**WELWYN HATFIELD BOROUGH COUNCIL  
EXECUTIVE DIRECTOR - PLANNING, PUBLIC PROTECTION AND GOVERNANCE**

**DELEGATED APPLICATION**

**Application No:** 6/2018/3188/OUTLINE  
**Location:** Warrenwood Manor (Equestrian area), Hornbeam Lane, Brookmans Park, Hatfield, AL9 6JF  
**Proposal:** Outline permission for erection of single storey equestrian building to form covered manege and riding area with landscape details reserved  
**Officer:** Mr David Elmore

**Recommendation:** Refused

Drawing Title  
 Indoor Riding Arena  
 Elevations & Typical Section  
 PROPOSED

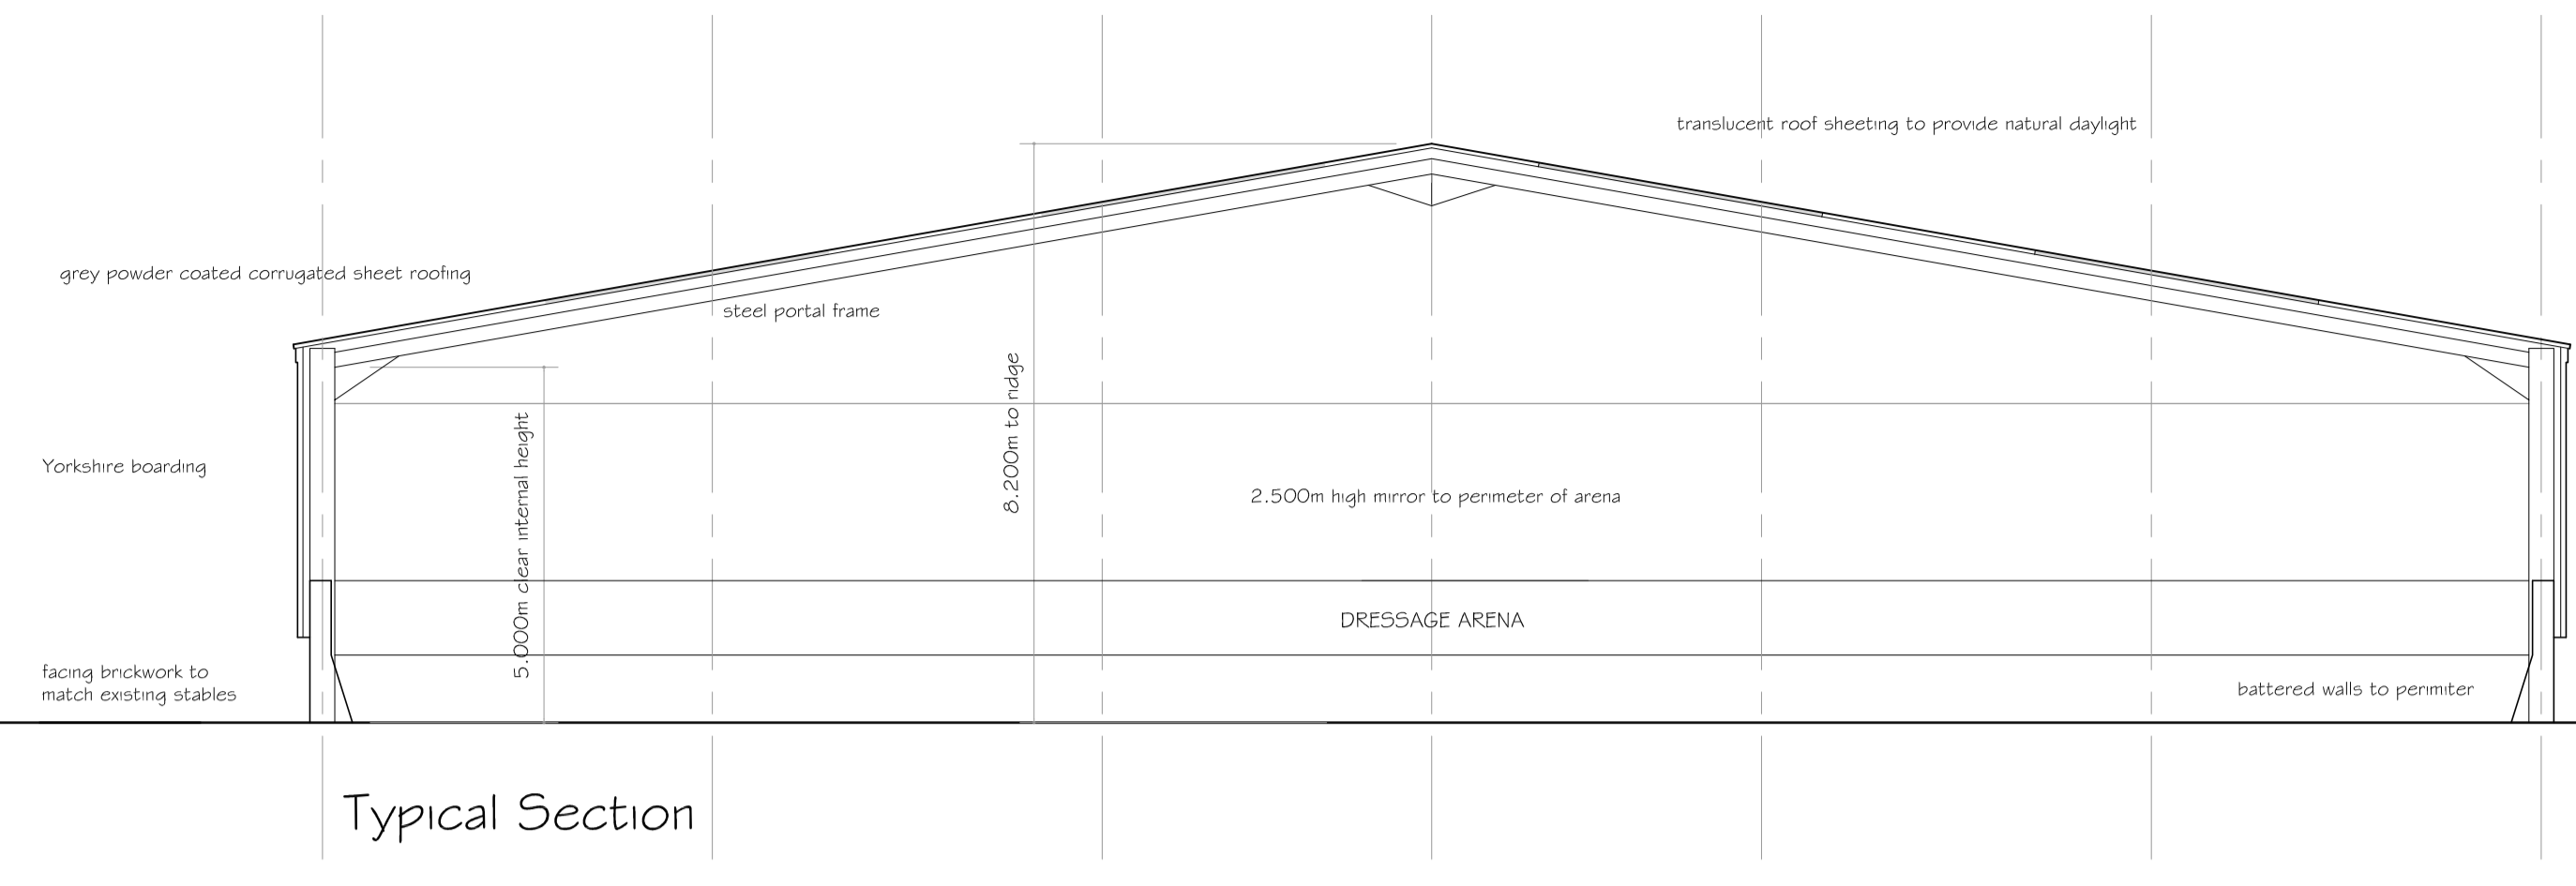
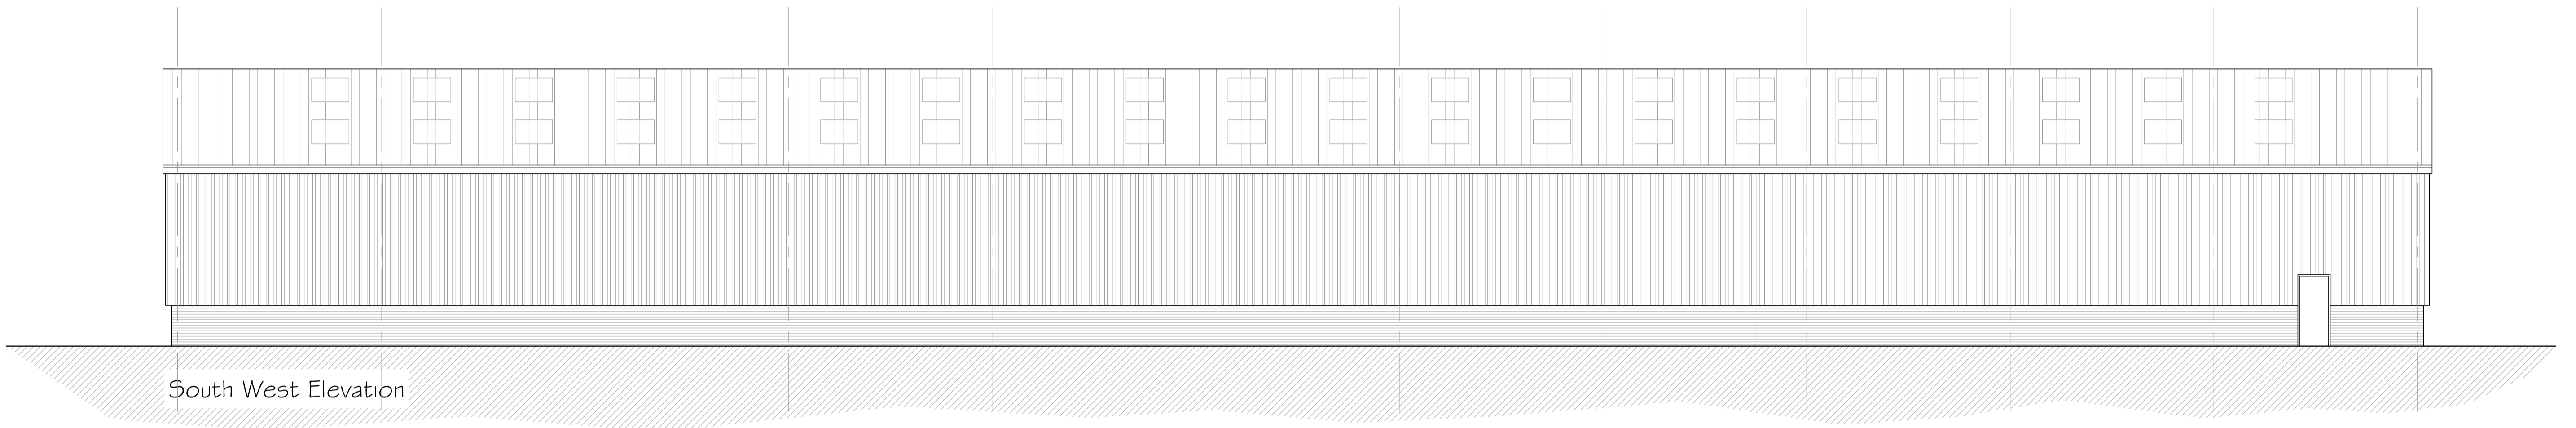
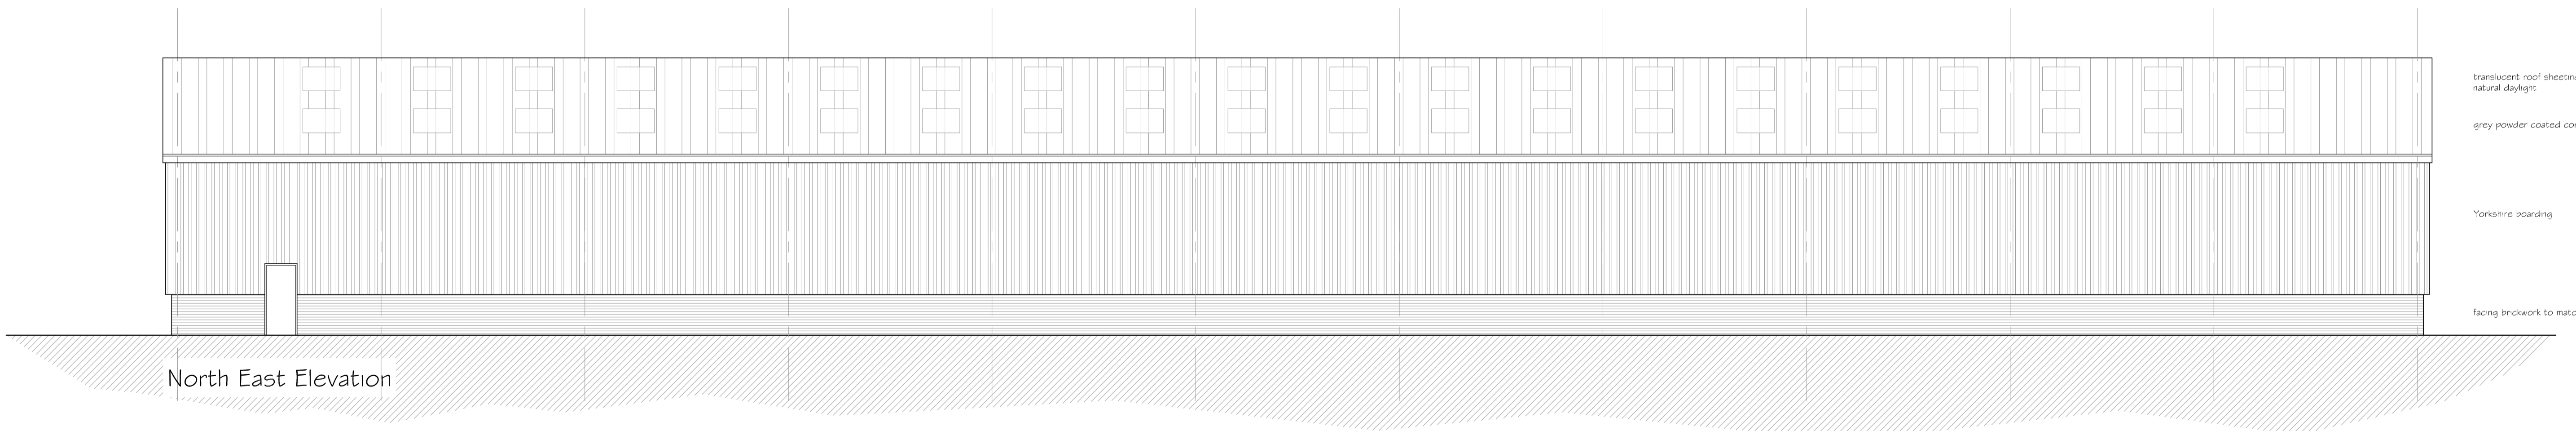
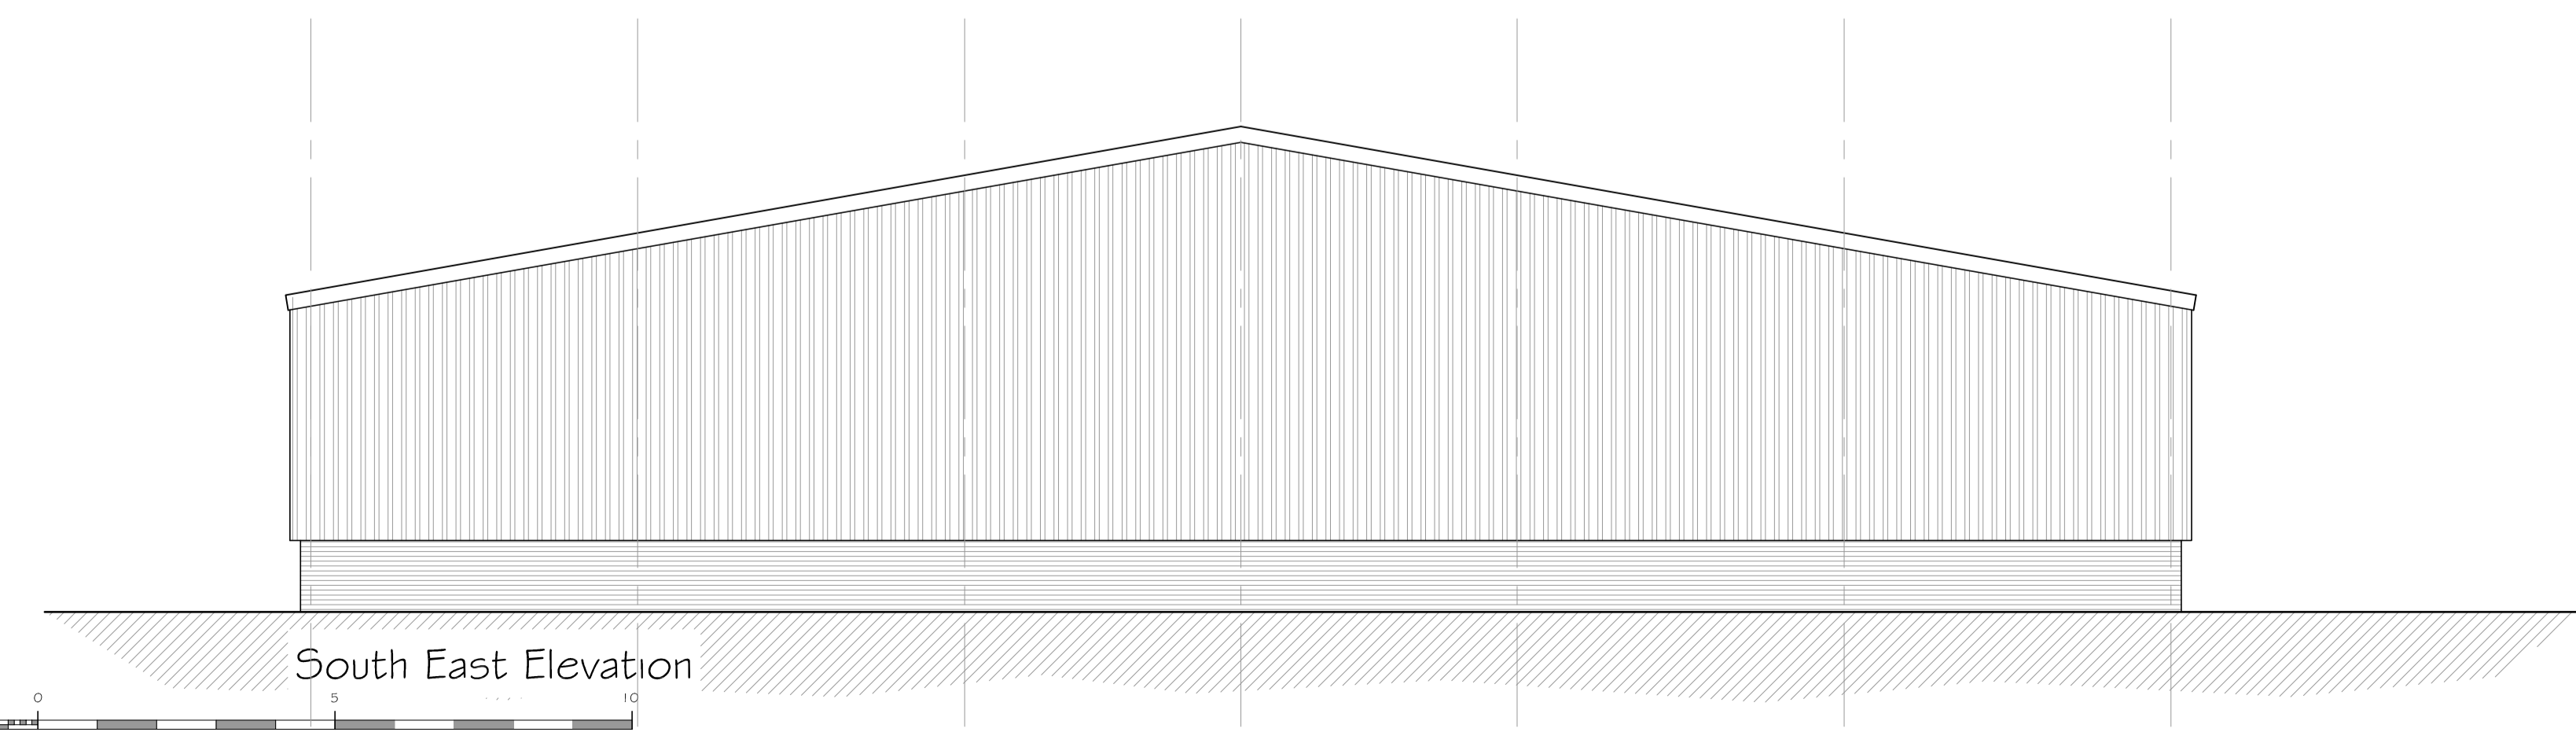
The site is washed over by the Metropolitan Green Belt. The proposed development is for a single storey building with a simple pitched roof. This building would have a footprint of 2,128sqm (66.5m long x 32m wide), eaves height of 5.4m and ridge height of between 8.1m-8.2m

Views of much of the north-west facing gable of the proposed building would be visible when approaching the site from Hornbeam Lane (i.e. the paved track portion). The height, width and scale of the building would be therefore clearly apparent from this public vantage point.

The narrower track of the bridleway immediately to the west of the site is well enclosed on both sides by established trees. These trees would inevitably reduce views of the proposed building, however the presence of this building would still be obvious by users of the bridleway particularly as a result of its sheer length – proposed at some 66.5m, and close proximity to the bridleway. Views of the building from this portion of the bridleway would be heightened when the trees are not in leaf.

Taking account of the above, it is considered that the proposed building by reason of its location, footprint, scale and bulk, would result in harmful loss of Green Belt openness in both a spatial and visual sense. Consequently, the proposal is inappropriate development in the Green Belt, in conflict with Policy GBSP1 of the Saved District Plan, Policy SADM34 of the Emerging Local Plan and the NPPF.
